Application by RWE Renewables UK Solar and Storage Limited for an Order Granting Development Consent for the Byers Gill Solar Project. PINS Reference No: EN010139.

BVAG Deadlines 9 & 9A Responses

BVAG Responses Deadlines 9 & 9A

Diagram Ref APP-048 '6.3.2.10 Environmental Statement Figure 2.10 Typical Inverter, Transformer and BESS arrangement

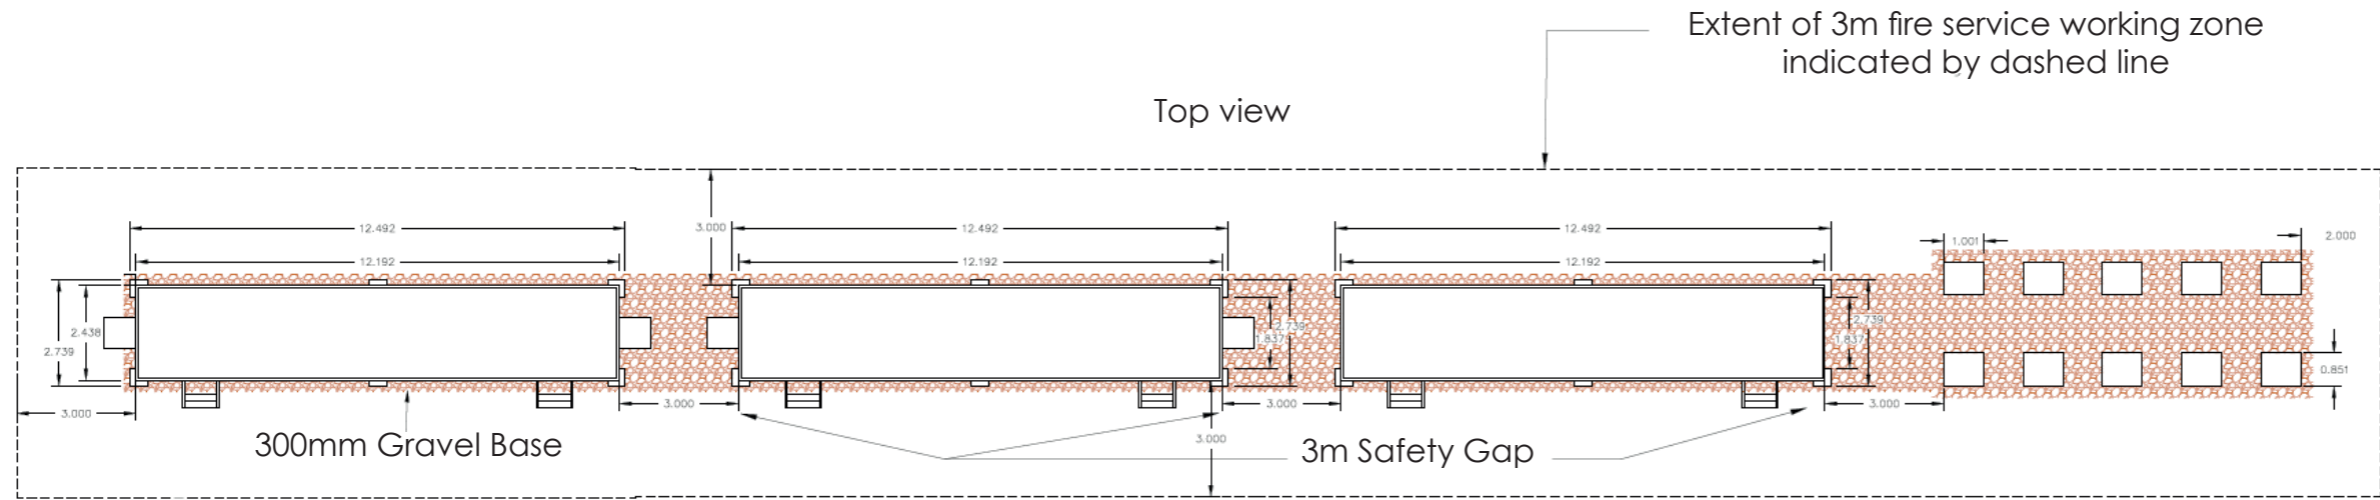
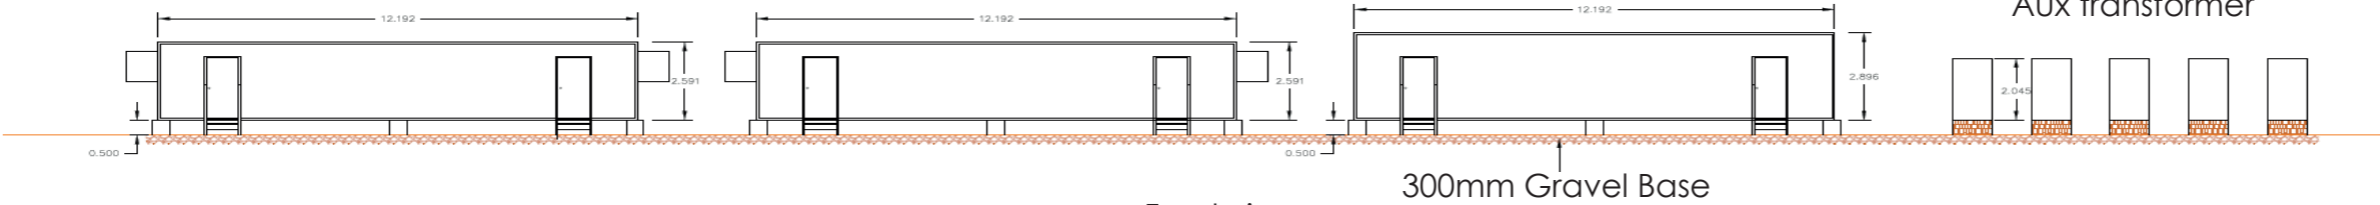
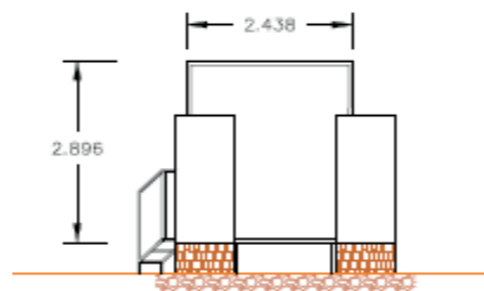
The Application describes 53 BESS units as part of 'hybrid units' with an inverter and a transformer across the site (Ref RWE DAD APP-165 superseded by AS-004). However, when looking at the design of the hybrid units in the DAD it appears as if each 'hybrid unit' has two batteries i.e. 106 battery units. Can the Applicant confirm / clarify this? See below extract from DAD of a 'hybrid unit':

- Q9. Can the Applicant please provide details of the Inverters, Battery packs and method of control that will both control and protect the systems?
- Q10. Can the Applicant confirm the total number of BESS units proposed to be installed throughout the Solar Site and type / size / capacity of the equipment housed in the BESS units?
